Town & Country Planning Act 1990 (as amended) s211 Notice

Prior Notification of Work to Tree(s) in a Conservation Area

Development: 1 No Wild Plum tree (T1) - Reduce height & spread to 6m.
1 No. Willow tree (T2) - Pollard back to previous pollard points. Finished branch length 4m.
3 No. Apple trees (T3, T4 & T5) - Reduce height & spread to 3m. 1
1 No. Bay Hedge (H1) - Reduced face and top back to previous level and line.

Location: The Old Malt House Main Road Yapton BN18 0EA

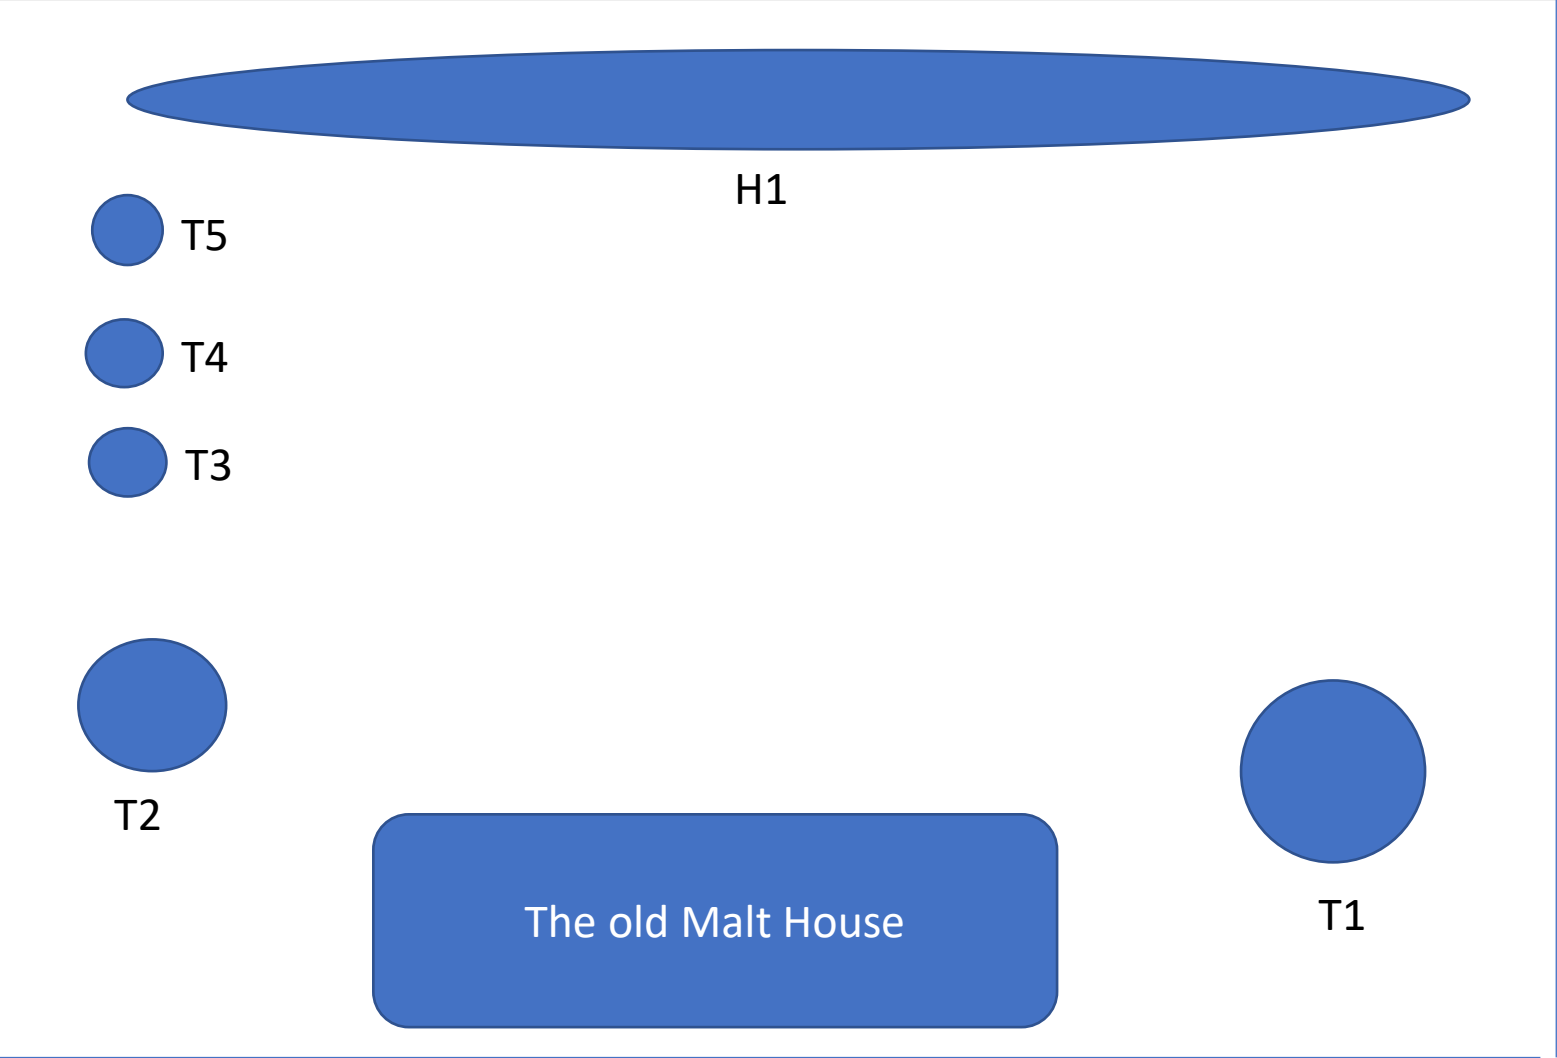
The sketch plan should include road names and adjoining properties, a North point is also helpful. Please amend accordingly and re submit.
